From: Sarah Burrow <Sarah.Burrow@arun.gov.uk>
Sent: 21 December 2021 16:41
To: Planning.Responses <Planning.Responses@arun.gov.uk>
Cc: Amber Willard <Amber.Willard@arun.gov.uk>; Paul Cann <Paul.Cann@arun.gov.uk>
Subject: RE: Planning Consultation on: BN/150/21/HH

Engineers Comments Regarding Surface Water Drainage

Application No: BN/150/21/HH
Registered: 18th November 2021
Site Address: 1 BATESON WAY BARNHAM PO22 0FL
Grid Reference: 496305 104069
Description of Works: Erection of single storey rear extension.

BH/BW/03

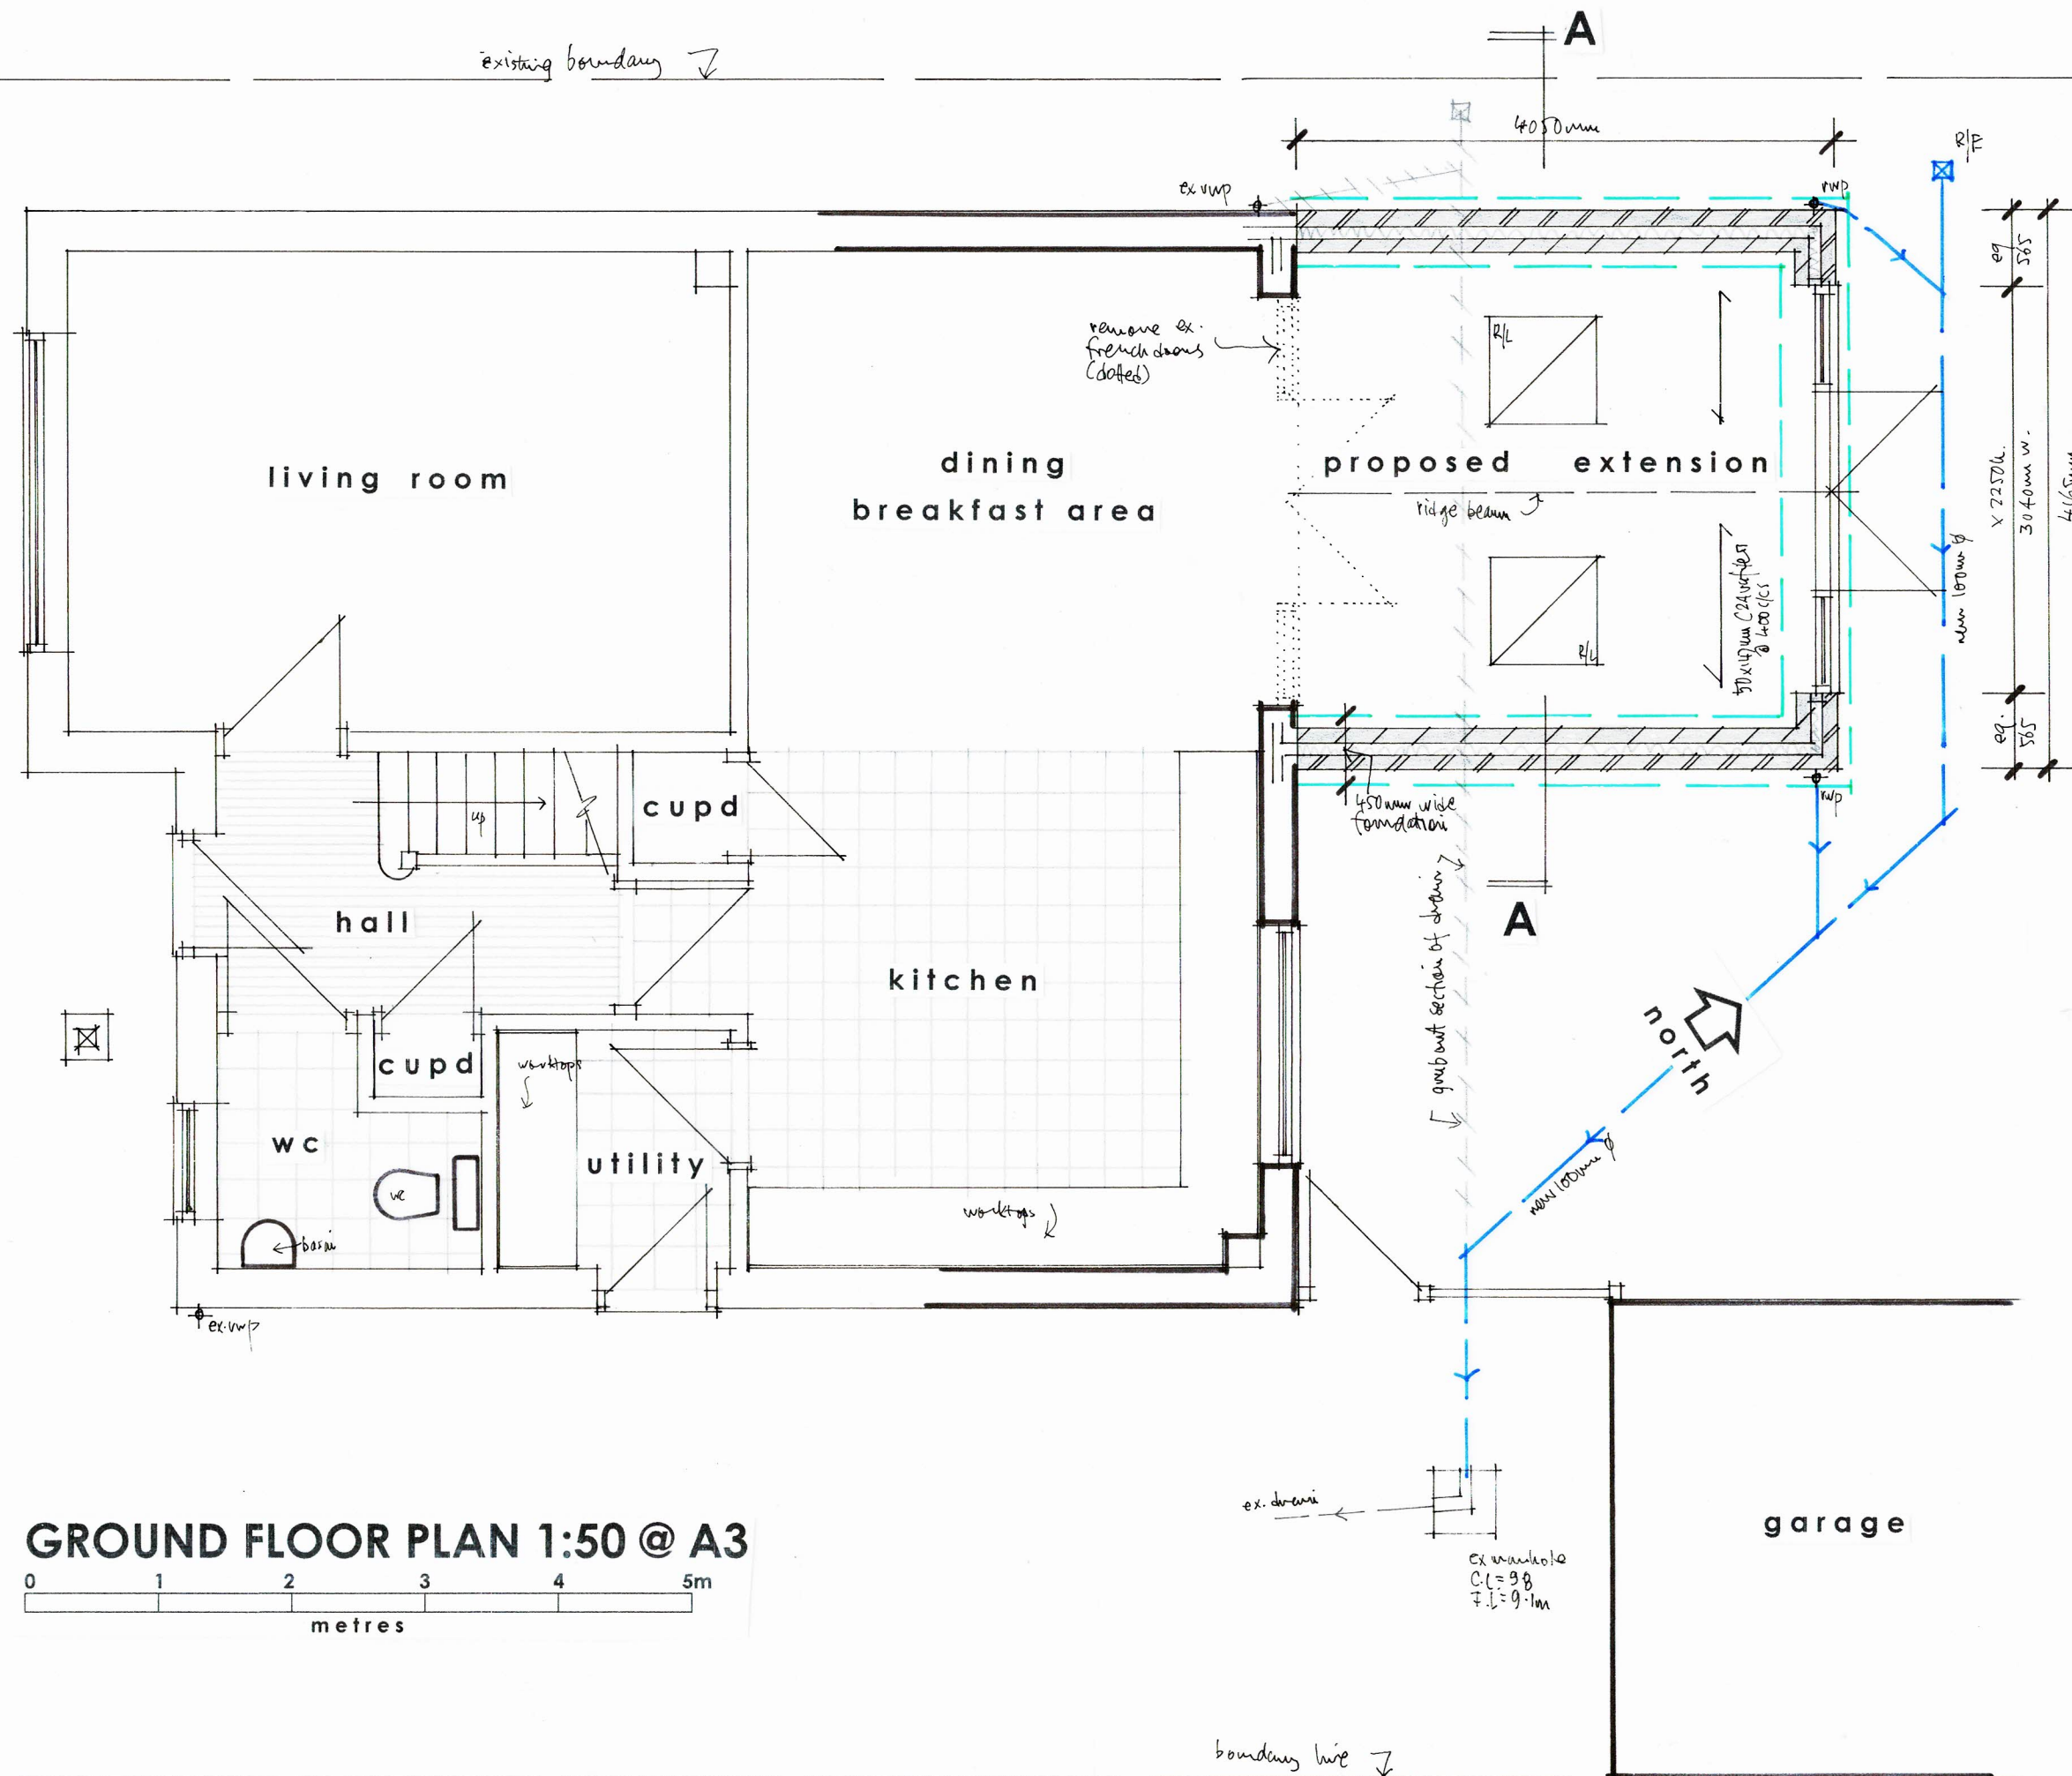
My expectation is that the applicant will need to show that they can and will connect the surface water drainage from the proposed extension to the existing surface water drainage system. At present we do not have as built drawings of the drainage system (these are subject to an outstanding discharge of conditions application). Therefore the applicant will need to check the levels of the inspection chamber (SIC in the snip below) and show that it has been constructed as drawn before connection is made to that inspection chamber. The
